ATTACHMENT 1

ISSUES AND COMMENTS - SSD 10467 – DATA CENTRE

11-17 Khartoum Road and 33-39 Talavera Road, Macquarie Park

TITLE: AUTOTRACKING OF 19m AV PLAN

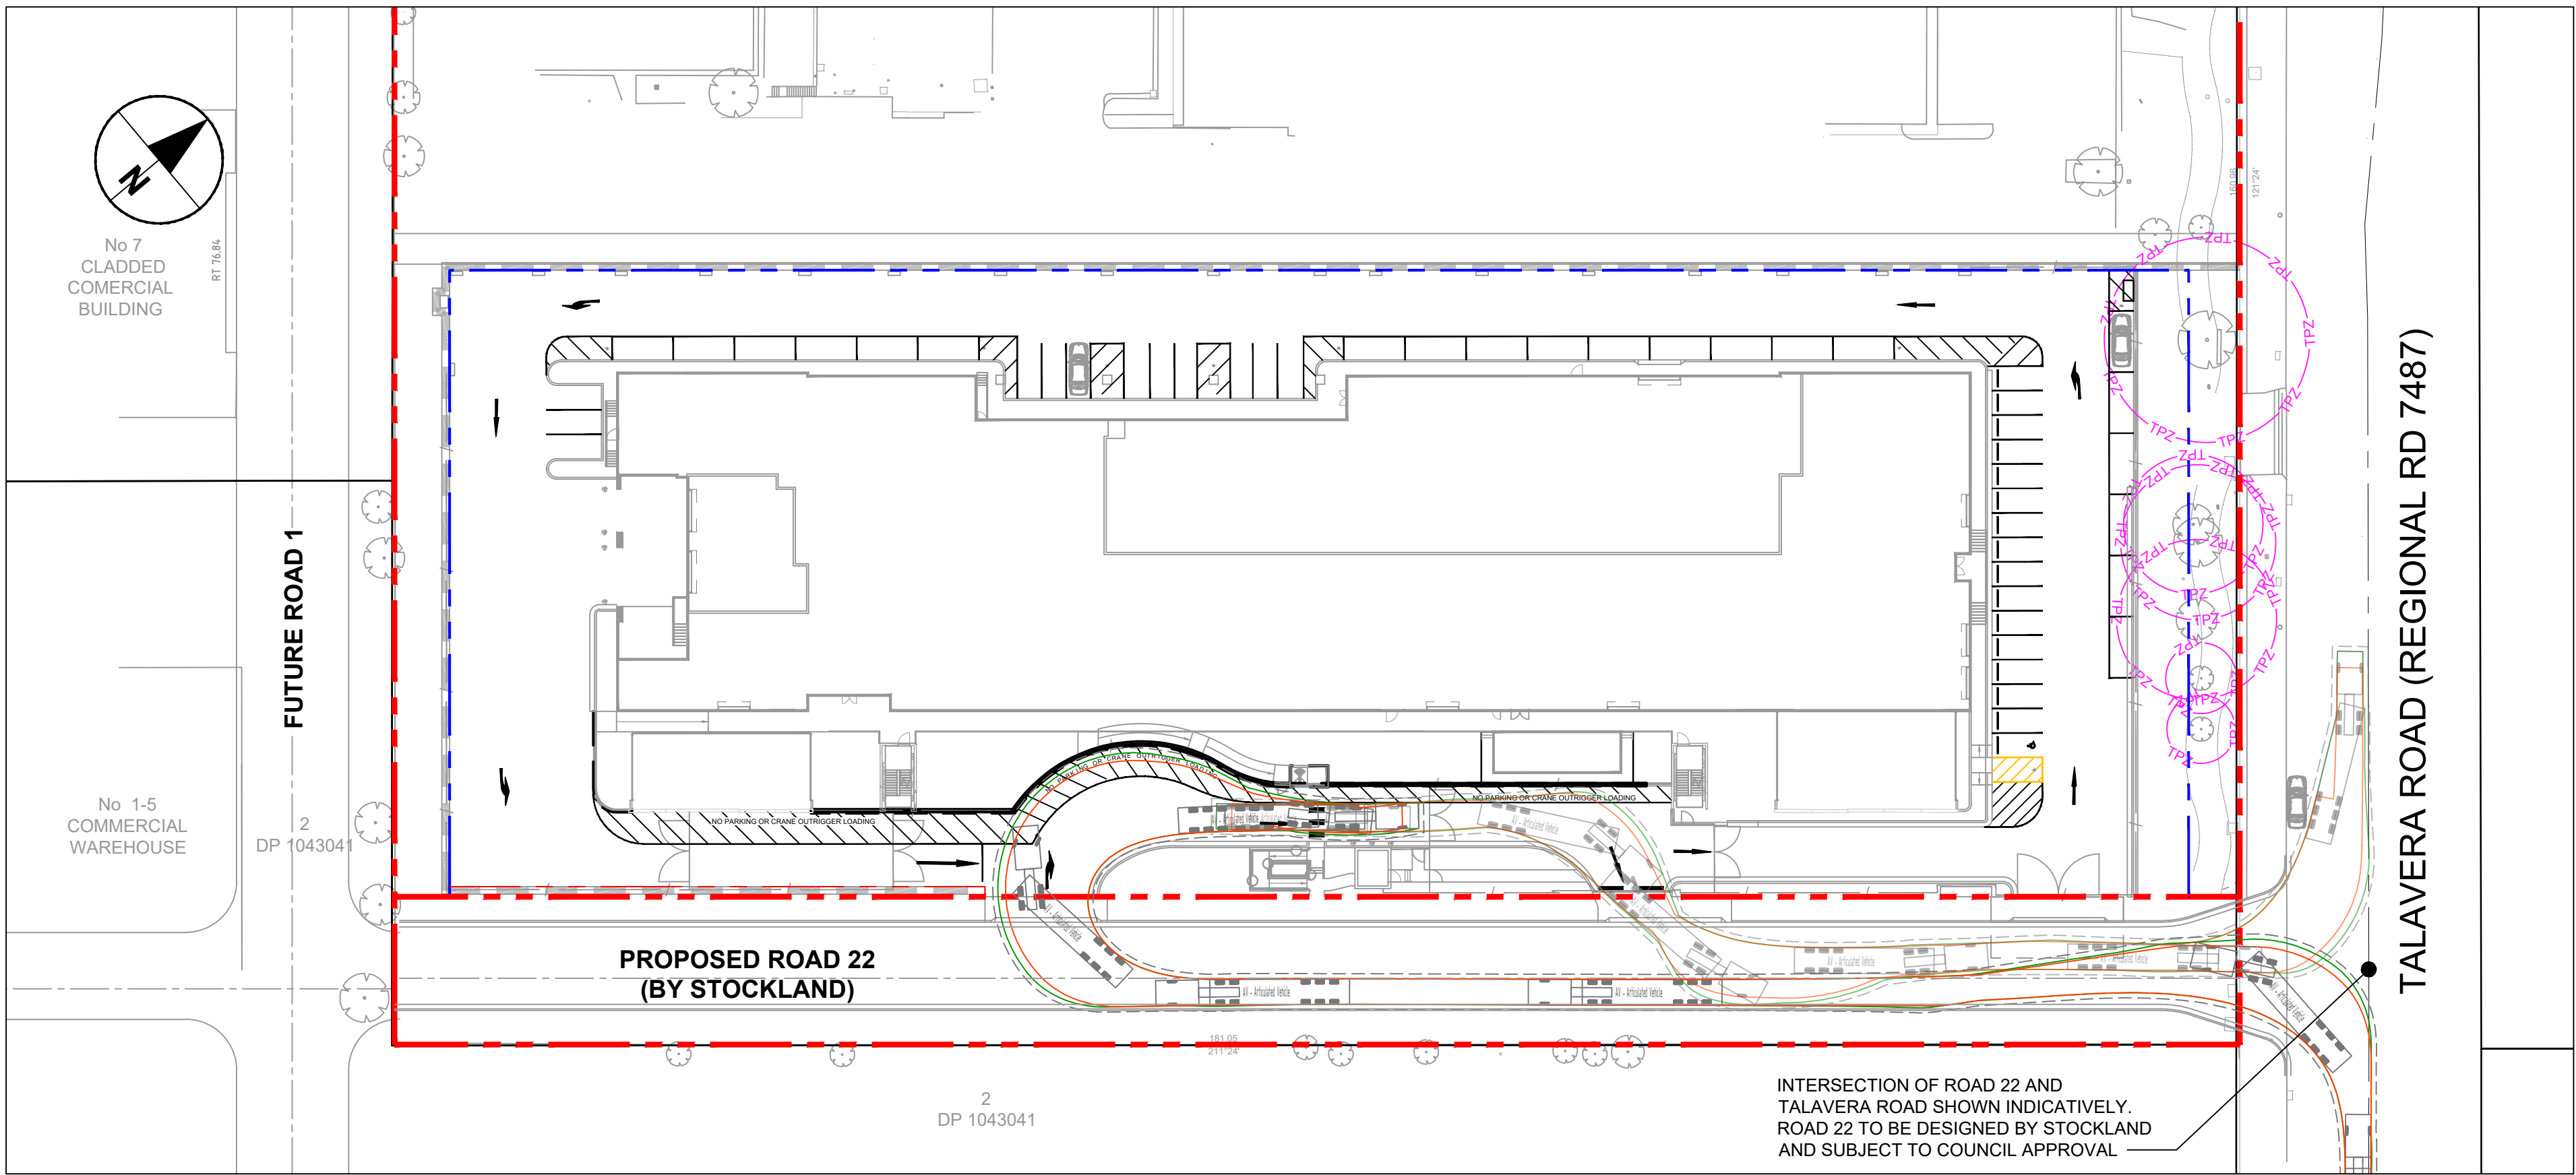
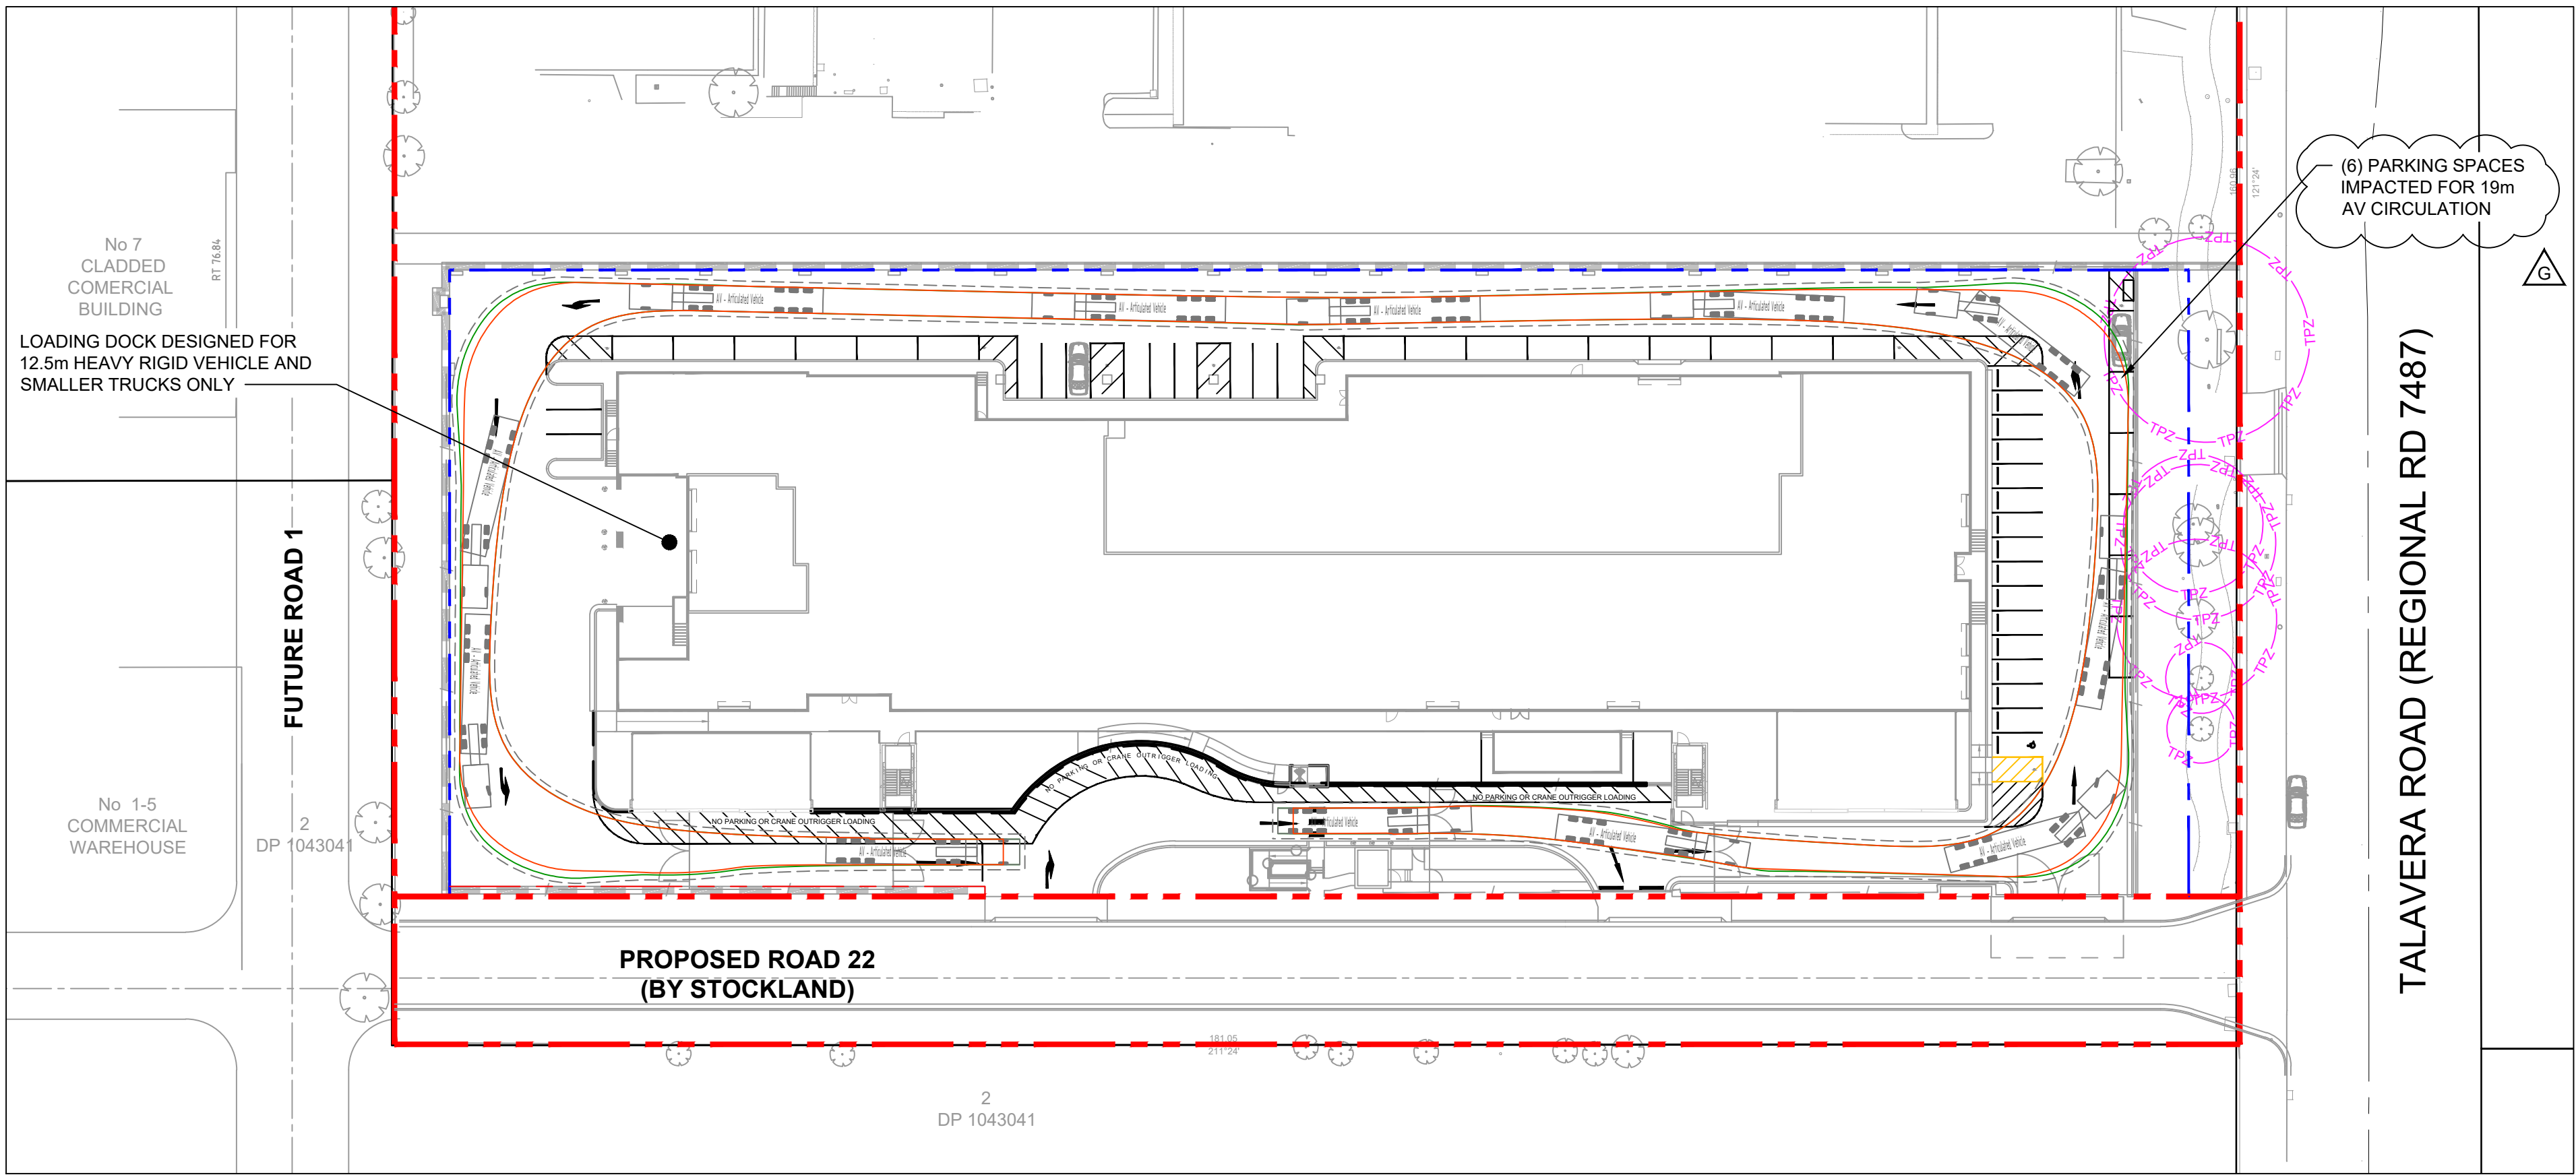
- The swept paths indicate that a 19m long semitrailer is unable to turn into Road 22 from Talavera Road without crossing over the centreline of Road 22. In this regard, the new intersection of Talavera Road and Road 22 is required to be amended such that the largest vehicle expected to service the site is capable of turning into Road 22 without affecting the traffic in the opposing direction.
